WEST SUSSEX COUNTY COUNCIL CONSULTATION

TO:	Arun District Council FAO: Zac Denton
FROM:	WSCC - Highways Authority
DATE:	8 October 2019
LOCATION:	141 Wick Street Littlehampton BN17 7JY
SUBJECT:	LU/297/19/PL 1 No. new dwelling (resubmission following LU/84/19/PL).
DATE OF SITE VISIT:	n/a
RECOMMENDATION:	Advice
S106 CONTRIBUTION TOTAL:	n/a

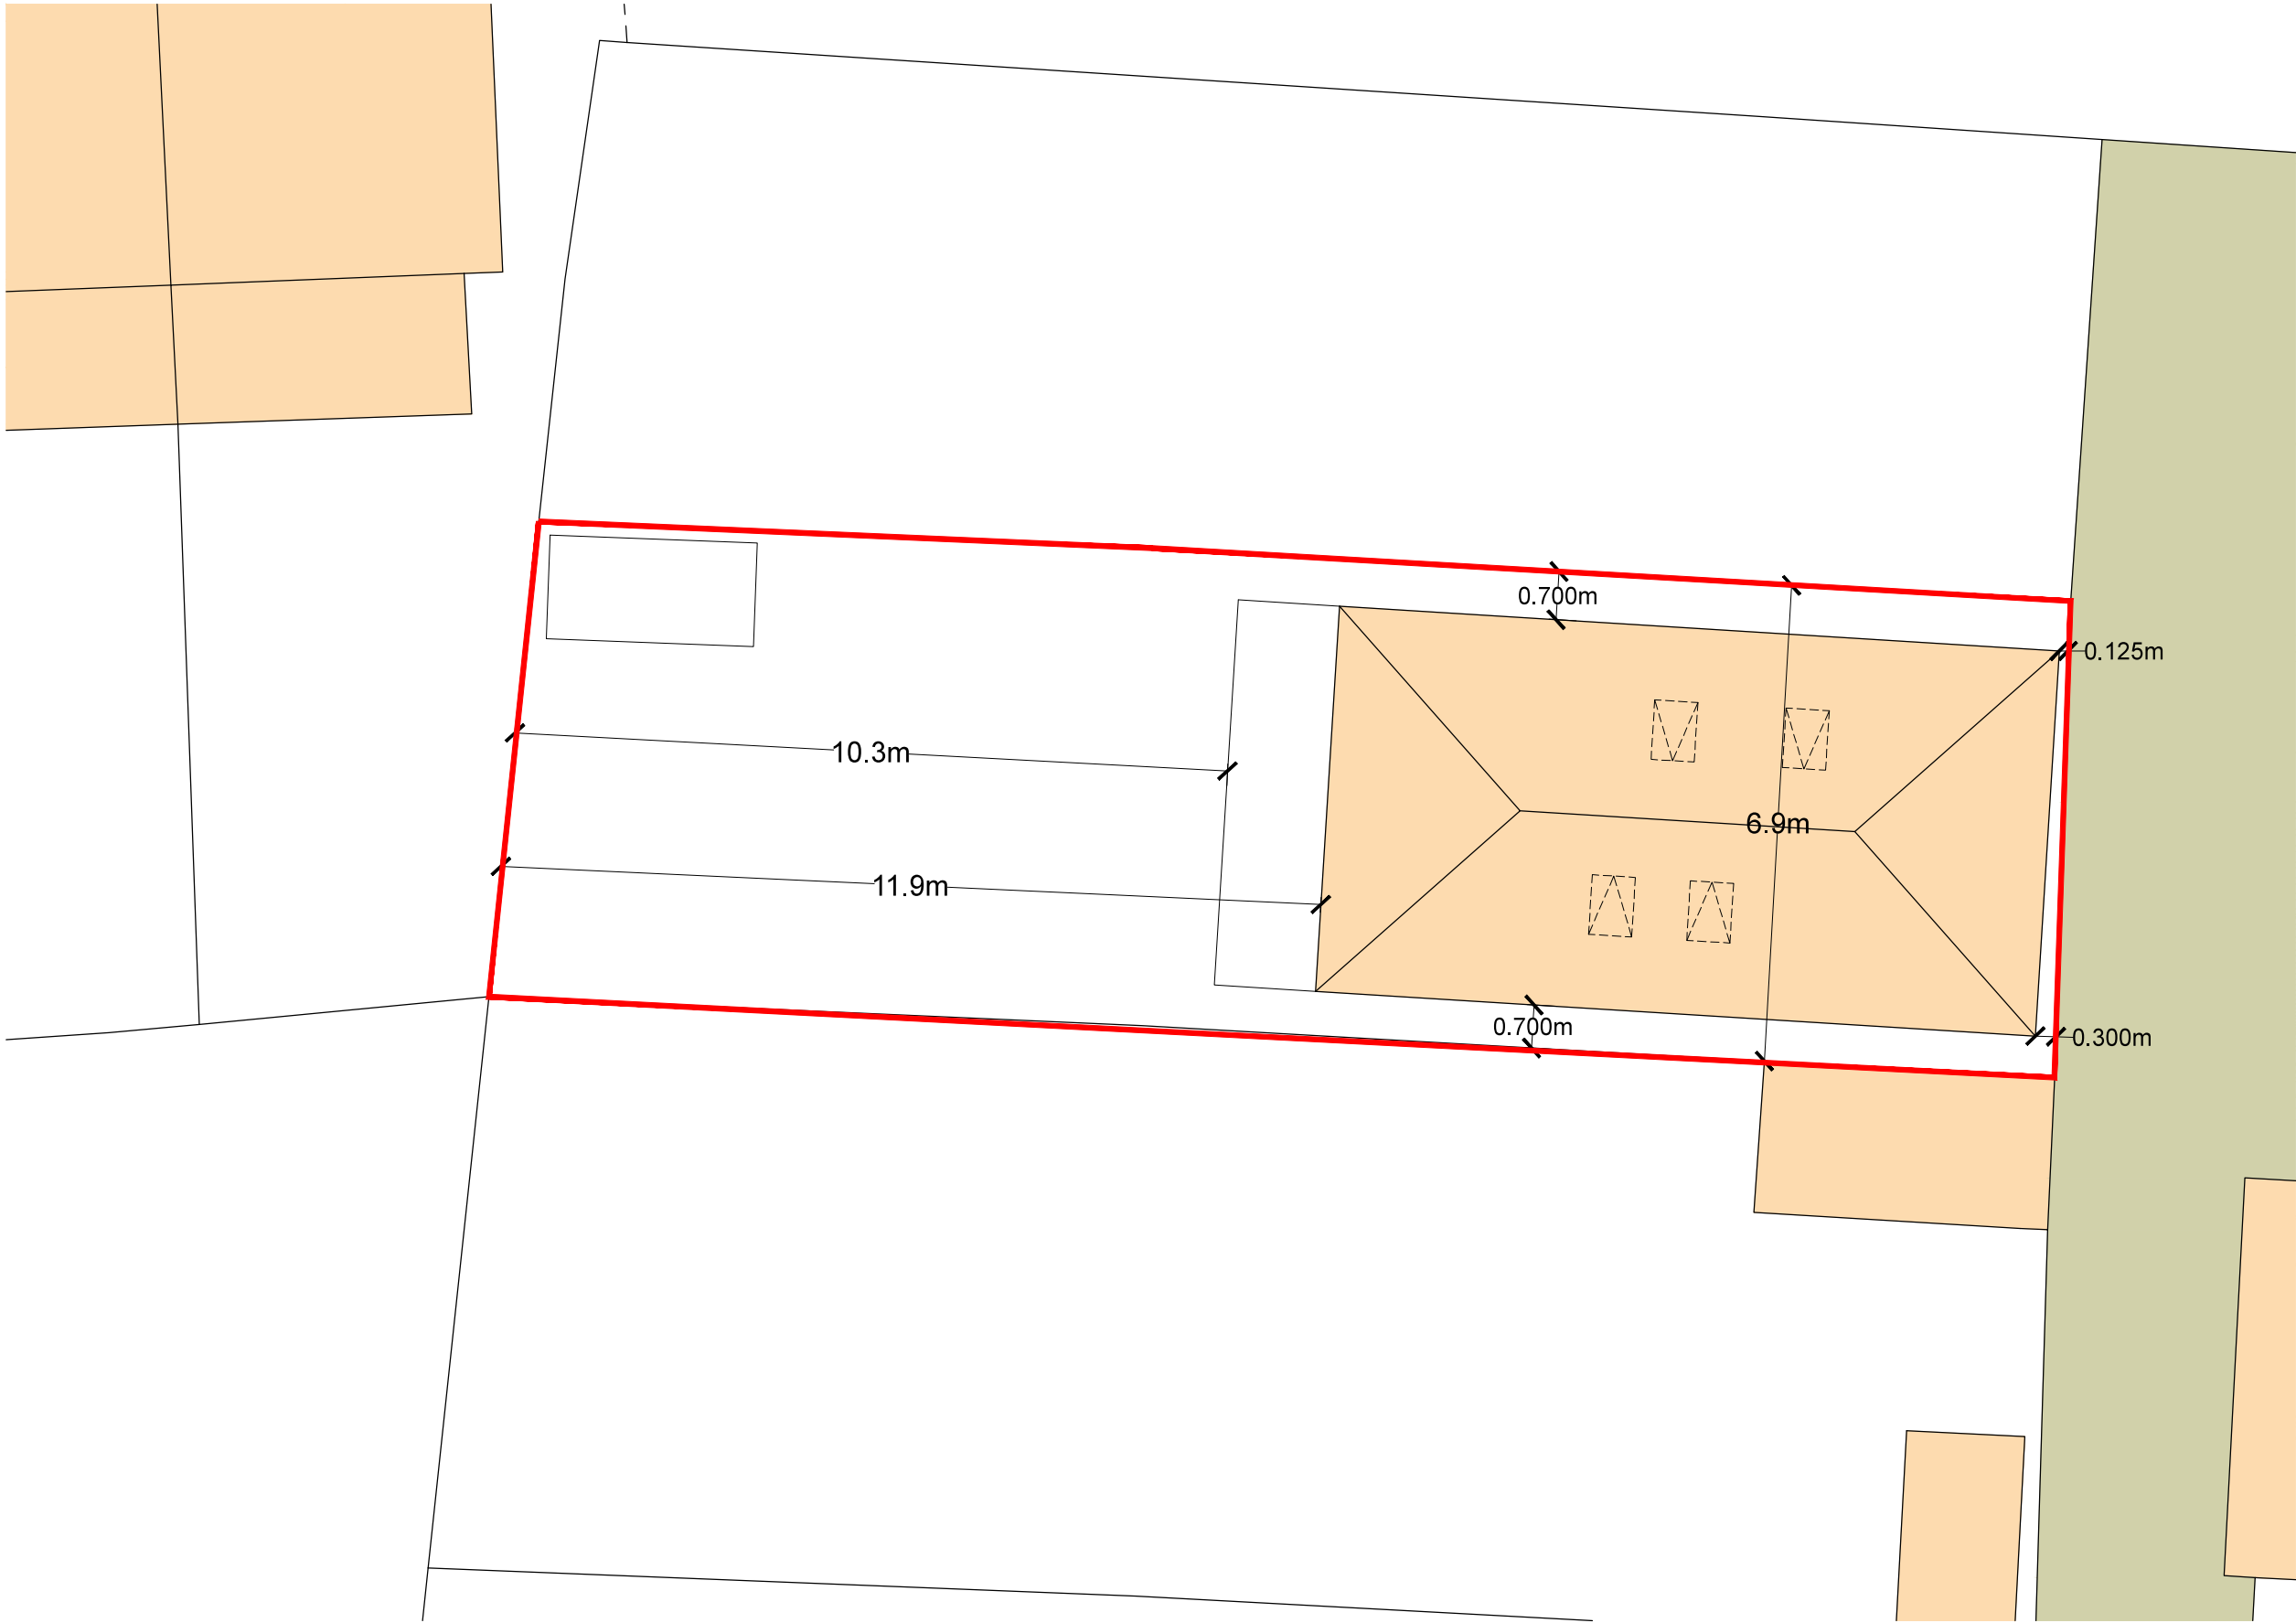
WSCC local mapping and plans show that the minimum width of the access is 2.5m. Consideration at the planning stage needs to therefore be given to emergency access and refuse collection in order to satisfy building regulations. It is appreciated that Wick Street provides access to other dwellings, which must have servicing requirements of their own. There is no indication of any waste storage or collection points on the

proposed site plan. The LPA would be advised to consult with the waste collection authority to determine the suitability of any waste collection point. It should be noted that if the preferred method of refuse collection is at the site access point onto Wick Street this would be in excess of waste carry distances as described in Manual for Streets (MfS) 6.8.9.

The applicant has demonstrated a garage with dimensions of 2.7 x 4.7 metres. This does not conform to the minimum WSCC and MfS guidance of 3 x 6 metres for a single garage and thus cannot be considered towards the parking demand of the dwelling. As a result the LHA will view the application on a NIL car parking provision. Under the WSCC Car Parking Guidance (adopted August 2019), 2 car parking spaces should be provided for the proposal. Whilst on-street car parking is limited in the immediate vicinity there are comprehensive parking restrictions prohibiting vehicles from parking in places that would be detrimental to highway safety. The LHA are also mindful that a free public carpark is located 40 metres to the North of the access, which could provide equal opportunities for overspill parking. We would not consider that highway safety would be detrimentally affected through the proposed NIL car parking provision. The Planning Authority may wish to consider the potential impacts of this development on on-street car parking.

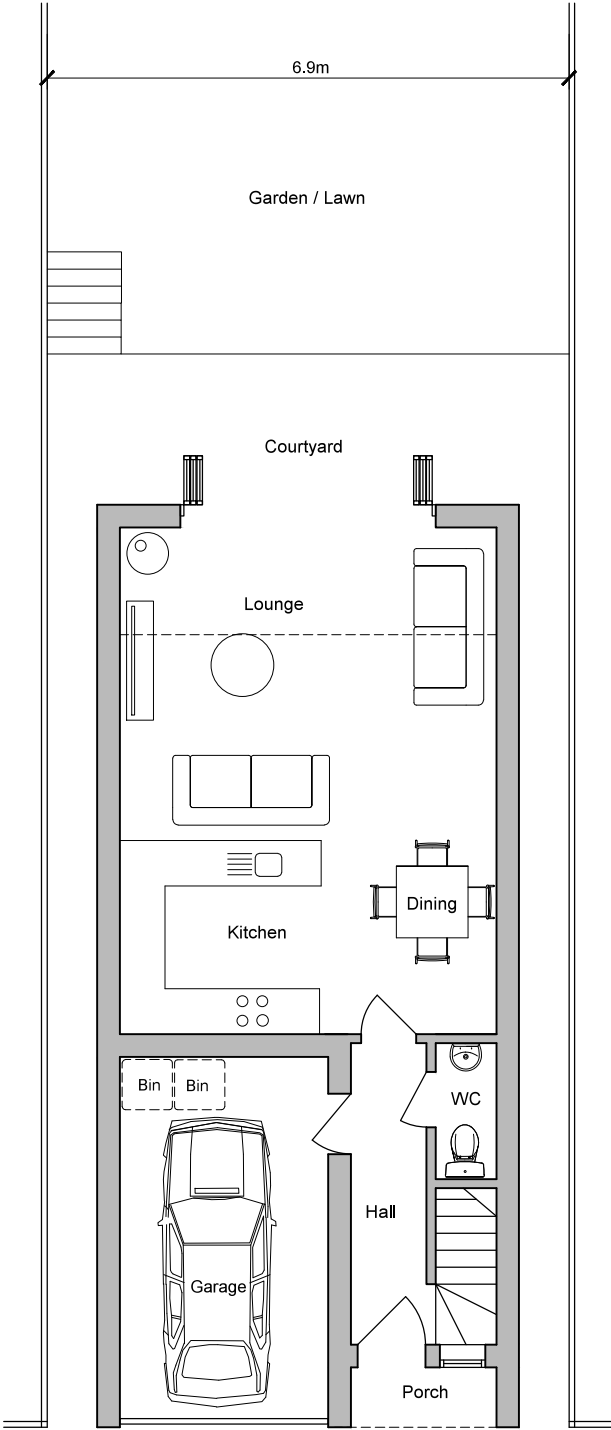
After inspection of the plans it is noted that the refuse storage will be located in the garage, although Manual for Streets does state that residents should not have to travel over 30m to put bins out and collection vehicles should not have to travel in excess of 25m to collect/deposit bins. This is however a matter of amenity for the Local Planning Authority (LPA) to consider. The applicant is advised to contact the waste disposal authorities to ascertain whether the practise would be acceptable and not require the relocation of the bin storage area.
